# PLANNING AMENDMENT

Holland House, High Street, Spalding

Description: Add entrance and associated  
portico to building

Amendment: Full revision of portico details  
(Drawing No. 96269/A2/13a)

Project Details		
PROPOSED ALTERATIONS TO HOLLAND HOUSE HIGH STREET SPALDING		
Date	Drawn	
APRIL 1997	UG	
Drawing		
REVISED PATIO DETAILS		
Client	Scale	
BROWN & CO	1:20	
Drawing Number		
96269/A2/13 A

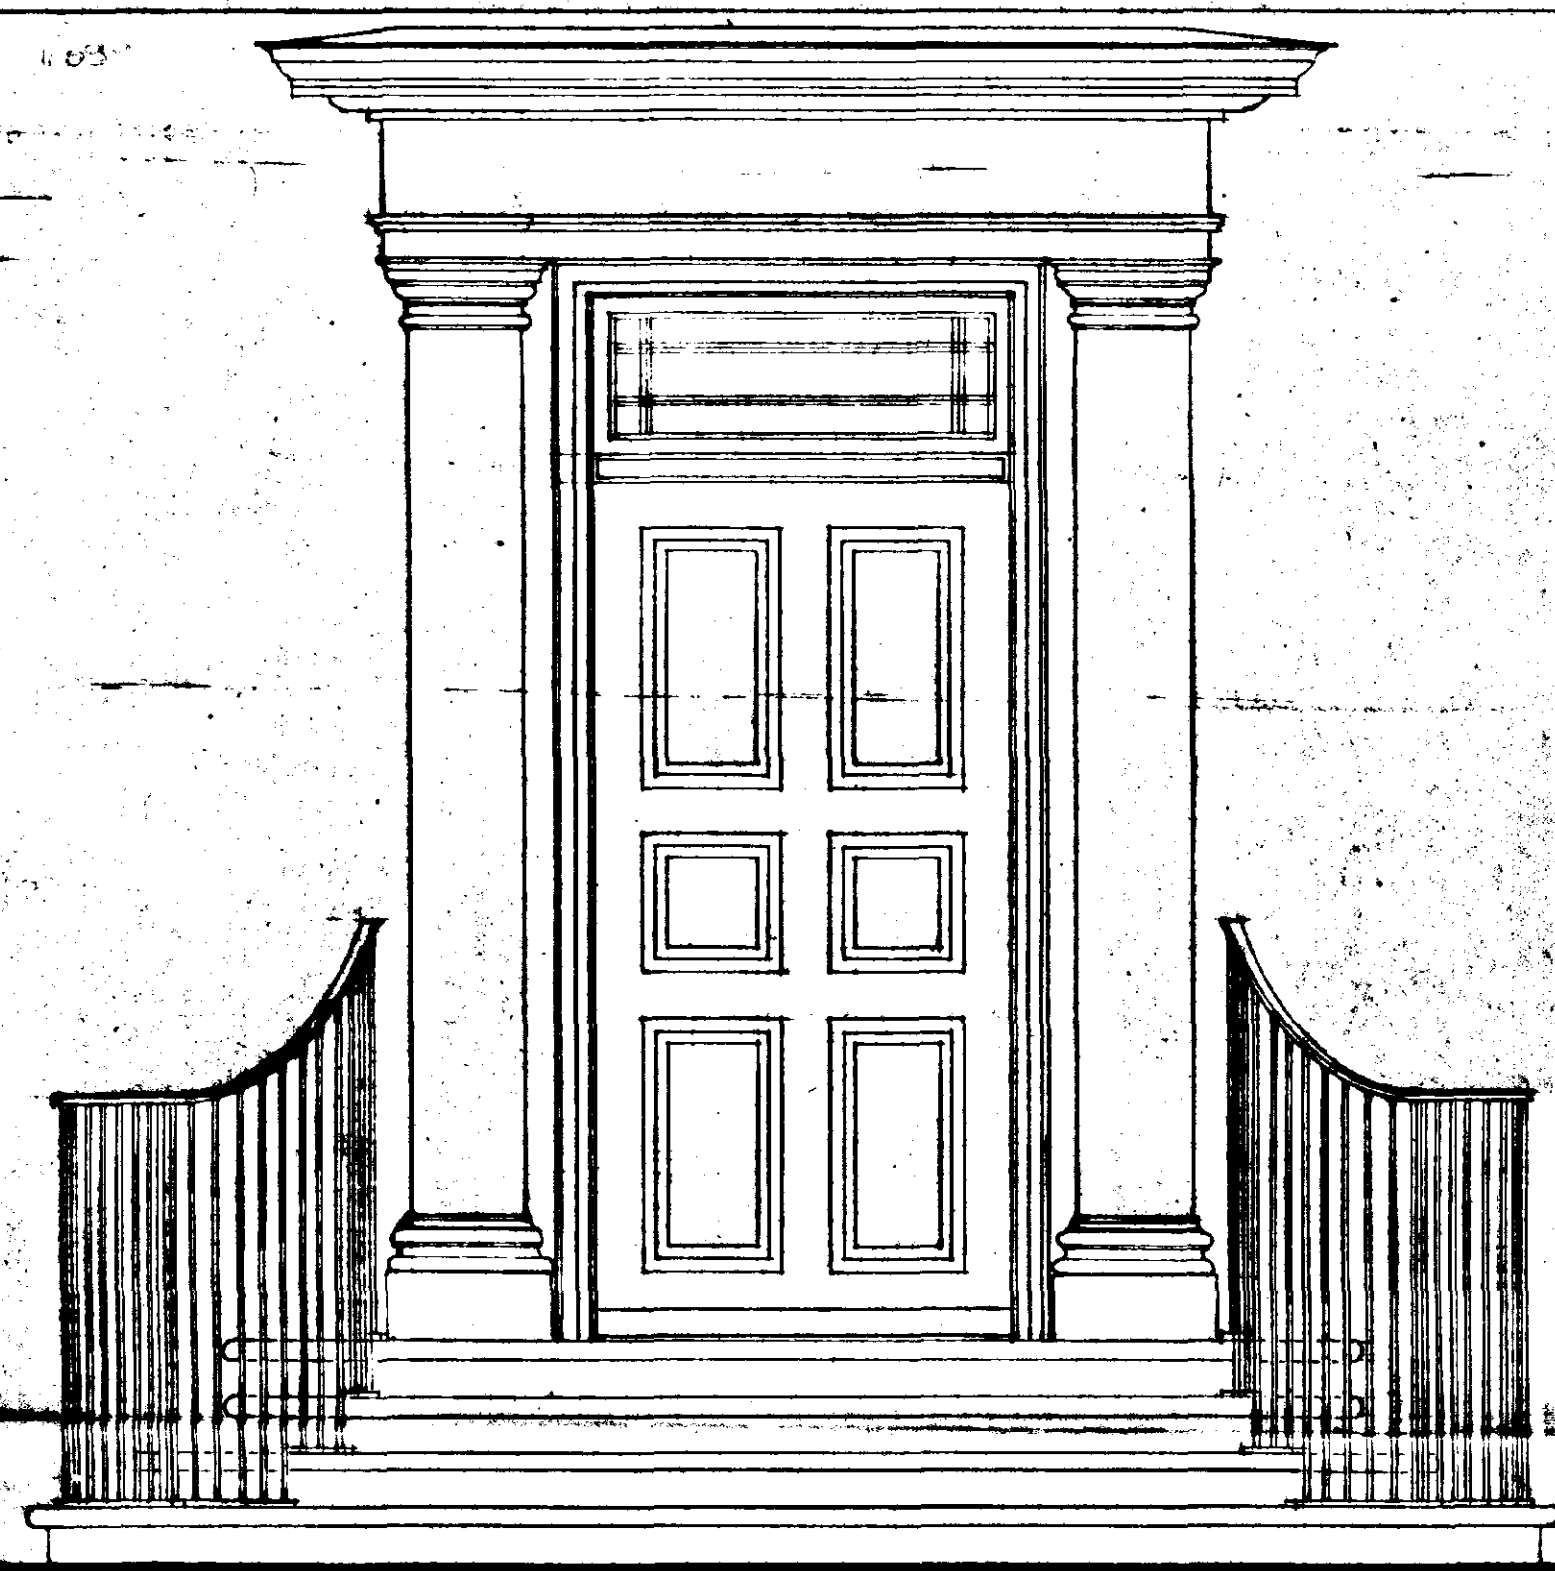
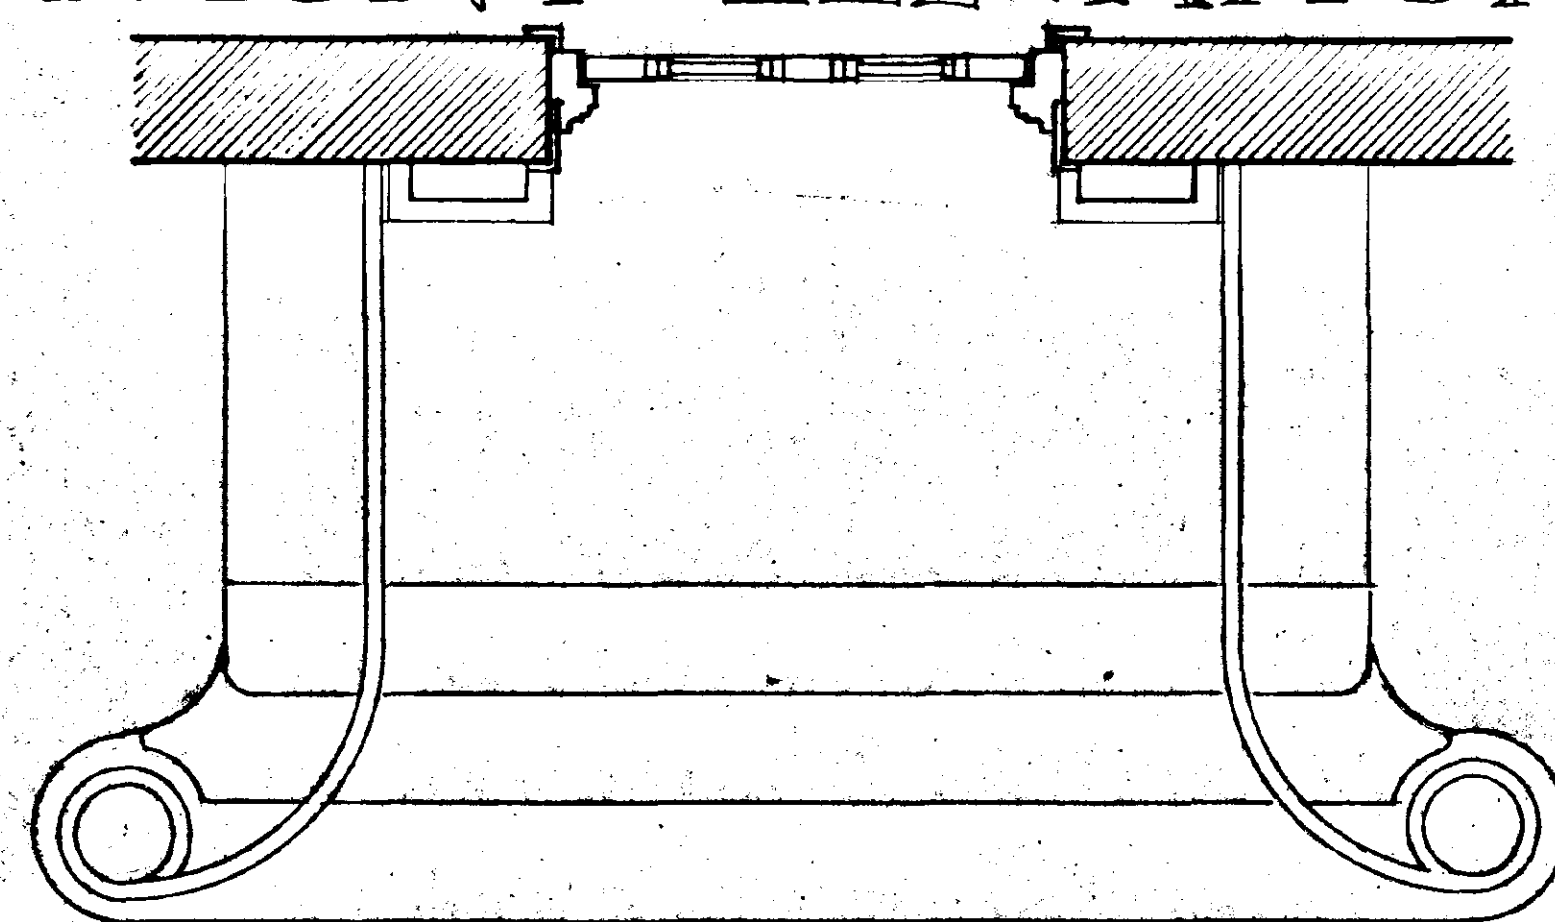
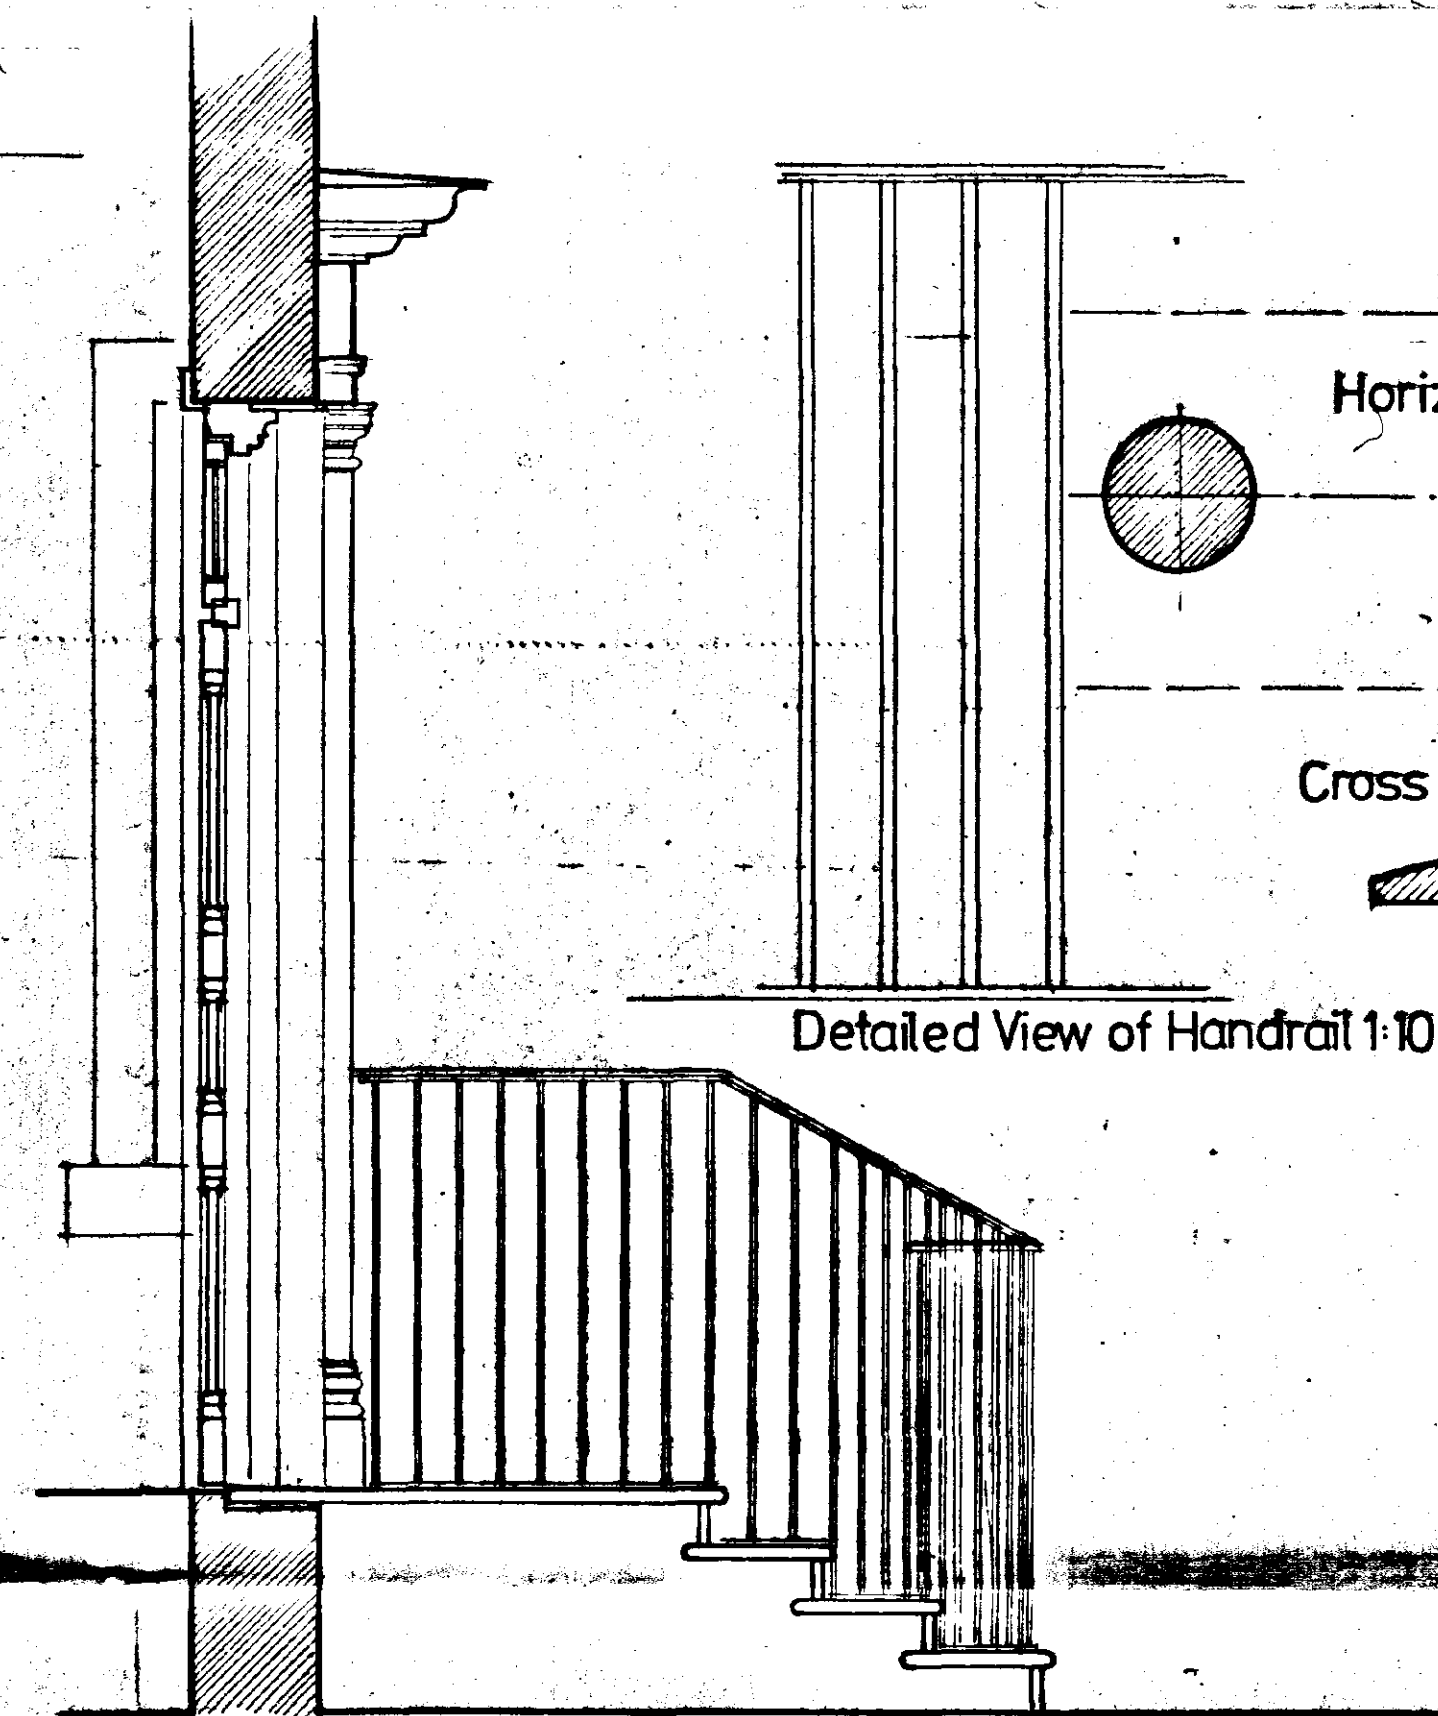
As shown in latest  
drawings - full revision  
of portico details as  
discussed + agreed  
at recent meeting

Amendment relates  
to portico + steps +  
handrail only - not req.
